2023/0755

Description: Subdivision of existing townhouse to 2no. one bed flats and a studio flat with external alterations including rooflight, rear dormer and external staircase.

Address: 212 Hough Lane, Wombwell, Barnsley, S73 0EX

FLOOR PLANS

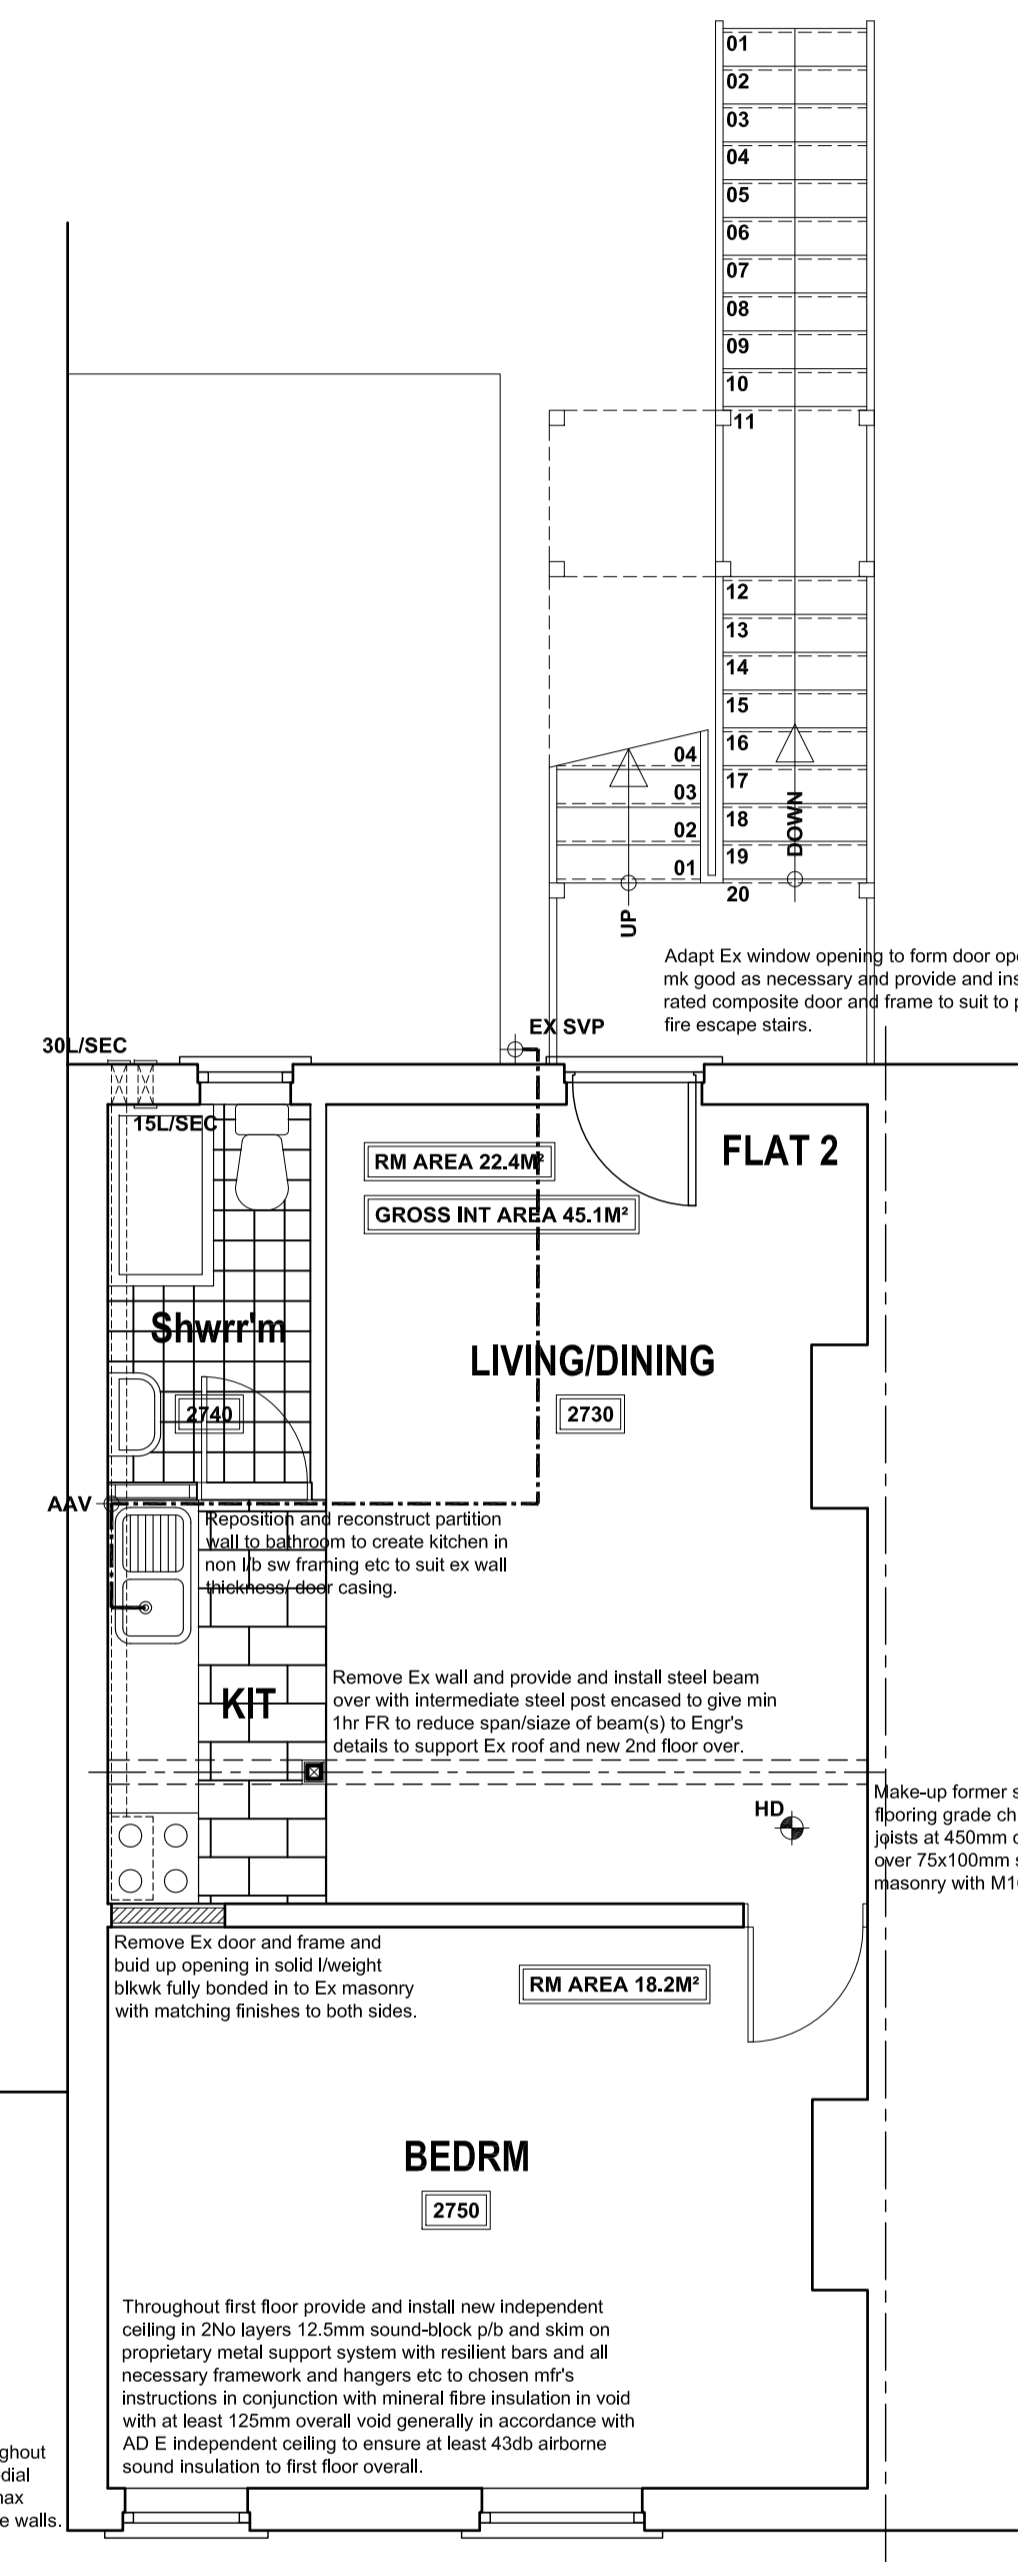
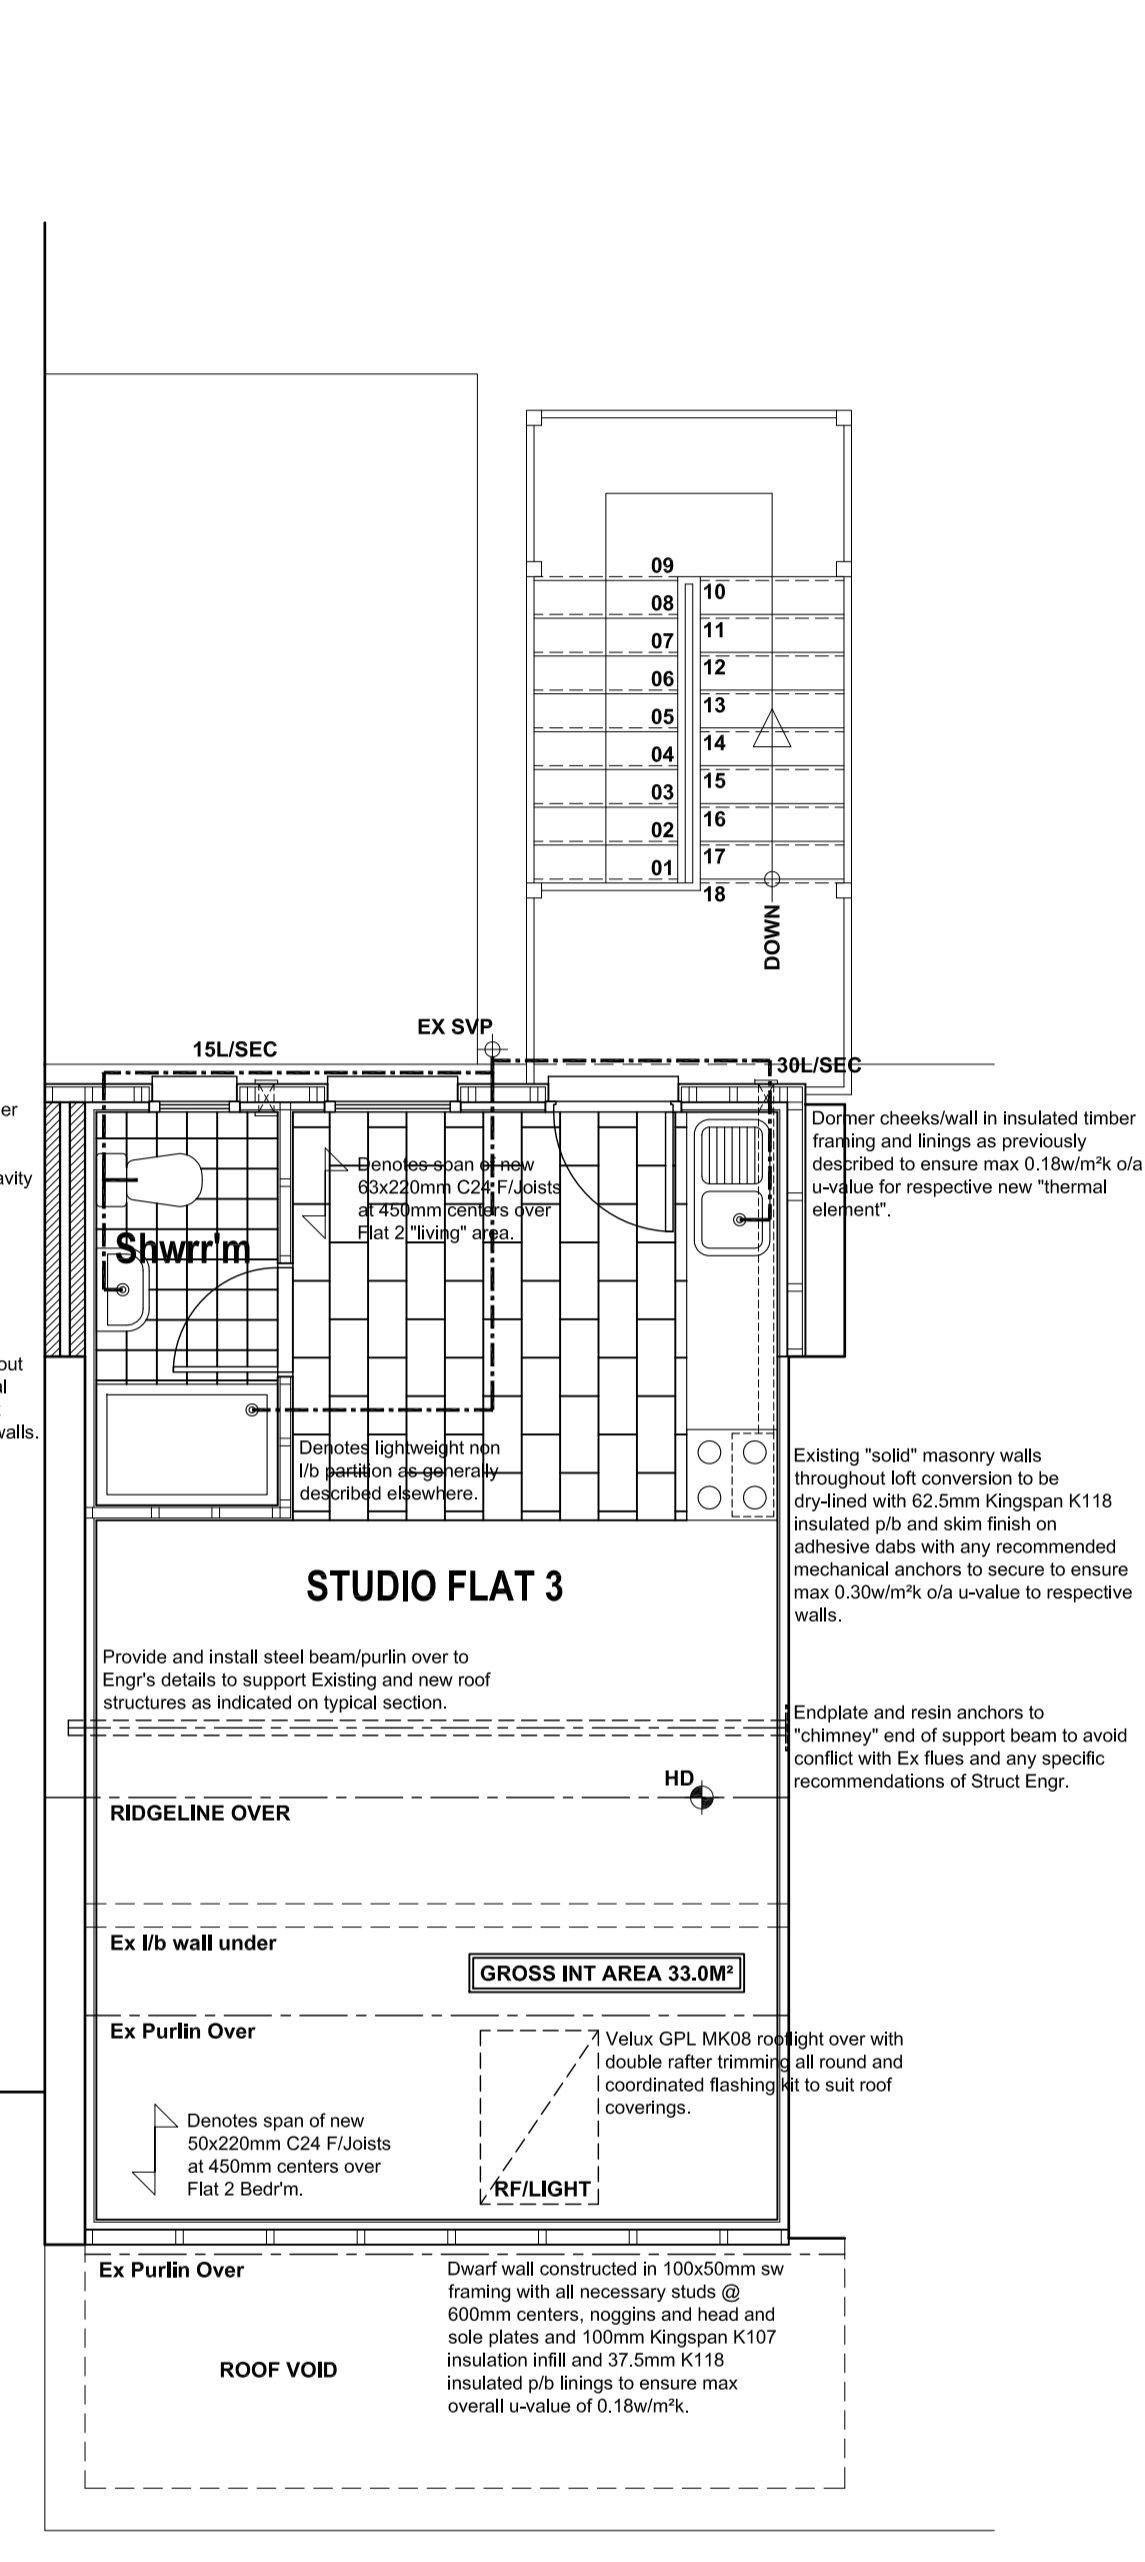
The submitted floor plans show that the overall units meet the overall floor areas as stipulated by the guidance in the South Yorkshire Residential Design Guide, however there is concern with individual room sizes and the amount of adequate daylight and sunlight the units are going to receive.

Flat 1's kitchen is undersized at 9sqm when it should be 13sqm. The living/dining room does not benefit from a window and for a main habitable room which would be arguably used mostly within the flat it would not be acceptable to have no natural daylight/sunlight. Flat 2's kitchen is incredibly small at 3.84sqm, almost 10sqm smaller than the stipulated standard. Again, the living/dining room does not have a window and nor does the kitchen. Flat 3 has not denoted all the rooms, however the kitchen is small and it appears any living space/bedroom would be served by a single rooflight which would not be acceptable. It is considered that the internal layout and lack of windows would lead to inadequate living standards for future occupiers which would not be in accordance with policy.

Whilst some elements of the proposal are acceptable, individual room standards are not met and there is a lack of window openings to habitable rooms. The proposed development is therefore unacceptable when measured against the Council's SPD for New Housing Development in that it provides insufficient internal and external amenity. The proposal is therefore unacceptable when measured against Local Plan Policy GD1 which seeks to protect the living conditions of future residents.

REAR (NORTH) ELEVATION

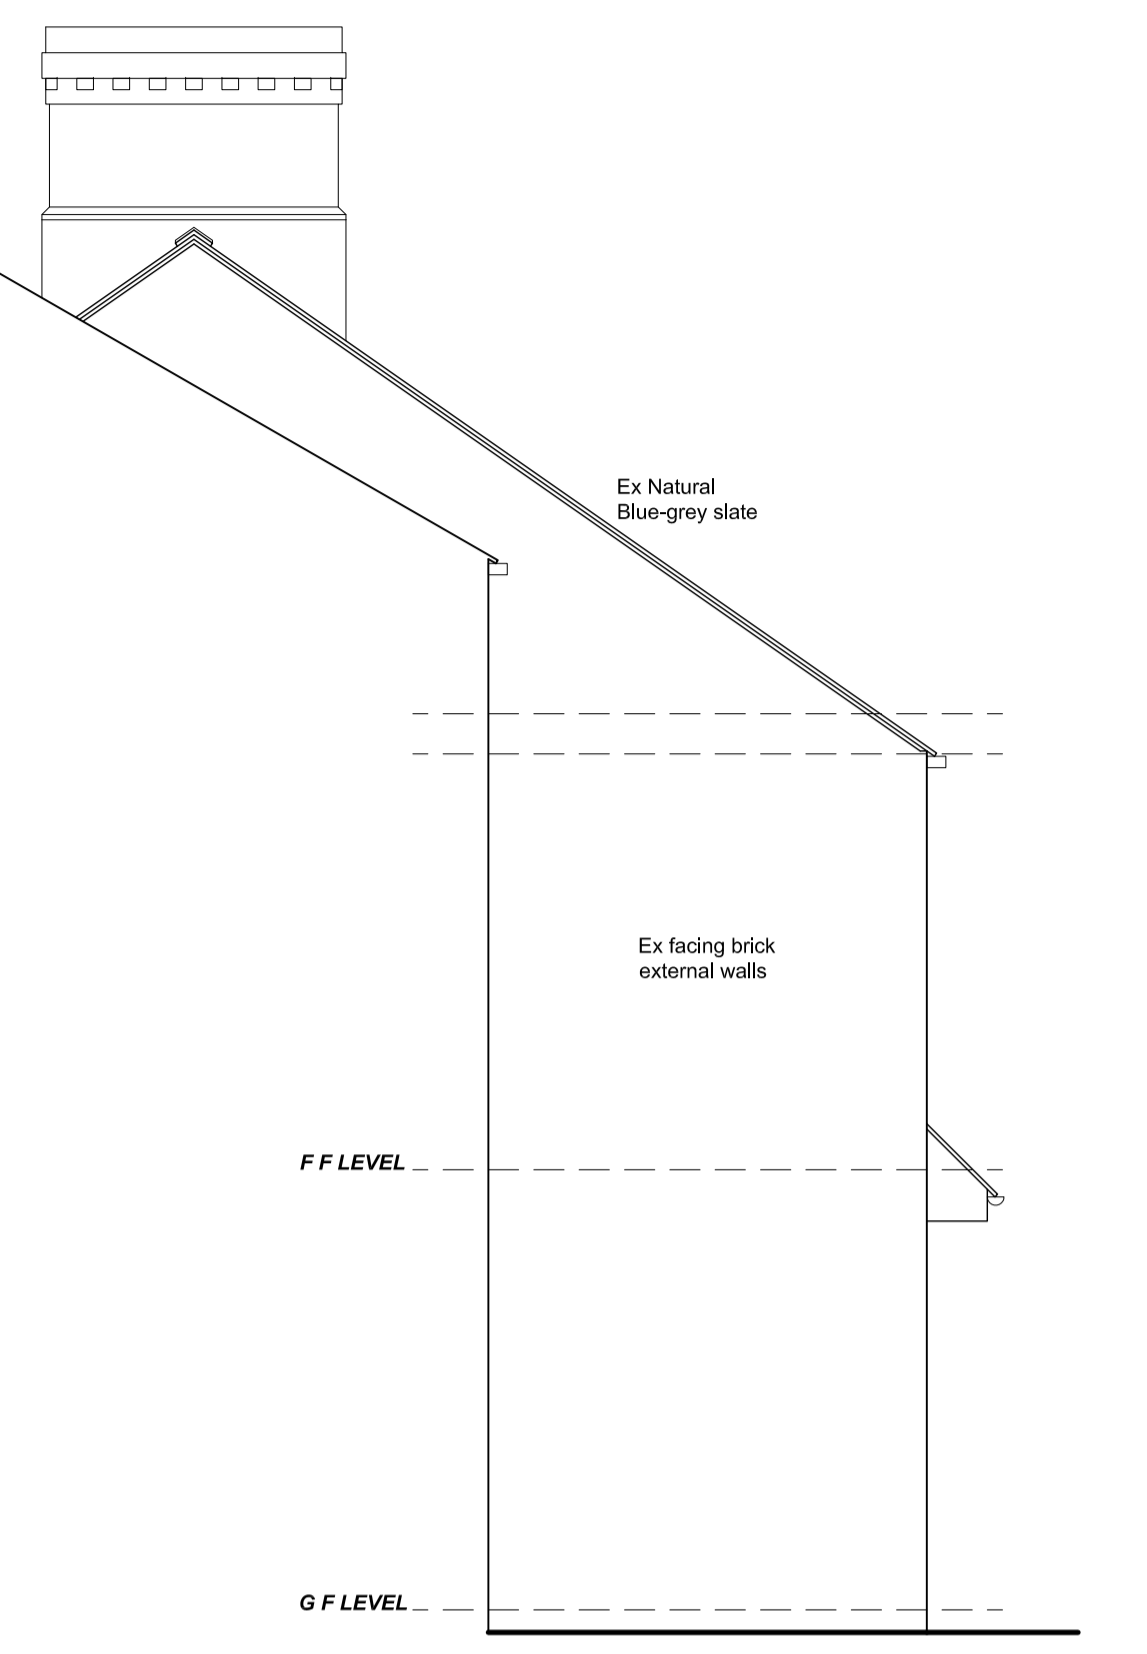
The dormer should not dominate existing roof lines and should retain its original form and as such the SPD states that dormers should be set within the roof plane and not be built off an external wall. The proposed dormer sits within the roof pane and the top of the dormer is set down below the ridge by 0.57m in accordance with the SPD. The SPD states that dormers should be at least 0.5m away from party walls with adjacent properties, however this is not complied with in this instance. Furthermore, the windows are not positioned to line through vertically with the openings below. In terms of materials, the dormer would be constructed from dark grey cladding and a grey GRP roof. This would not be in keeping with the existing building and would be contrary to the SPD which states that cladding to the front of a dormer should be minimised. As such, the dormer does not comply with the SPD, would be at odds with the existing building and would be seen from dwellings and public vantage points to the rear of the dwelling and not assimilate well with the existing area. It is therefore poor design which is unacceptable in this instance. It is noted that the adjacent dwelling currently benefits from a front dormer, however this is not a recent addition to the building and there have been updated policies in place as discussed above since the adjacent dormer was constructed.

In terms of the staircase, it appears to be clunky and would dominate the rear of the property and obscured views may be possible from the adjacent dwelling. Policy D1, High Quality Design and Place Making, states that design should respect, take advantage of and reinforce the distinctive local character and features of Barnsley. The staircase is not in accordance with this policy, being again at odds with the existing building and local area. It is considered that a different approach could have been taken to obscure the staircase or alternatively an internal design solution should have been considered.

As such, the proposal introduces design which is not acceptable and would impact on the visual amenity of the property itself and surrounding area, contrary to the House Extensions and Other Domestic Alterations SPD and policy D1 of the Local Plan.
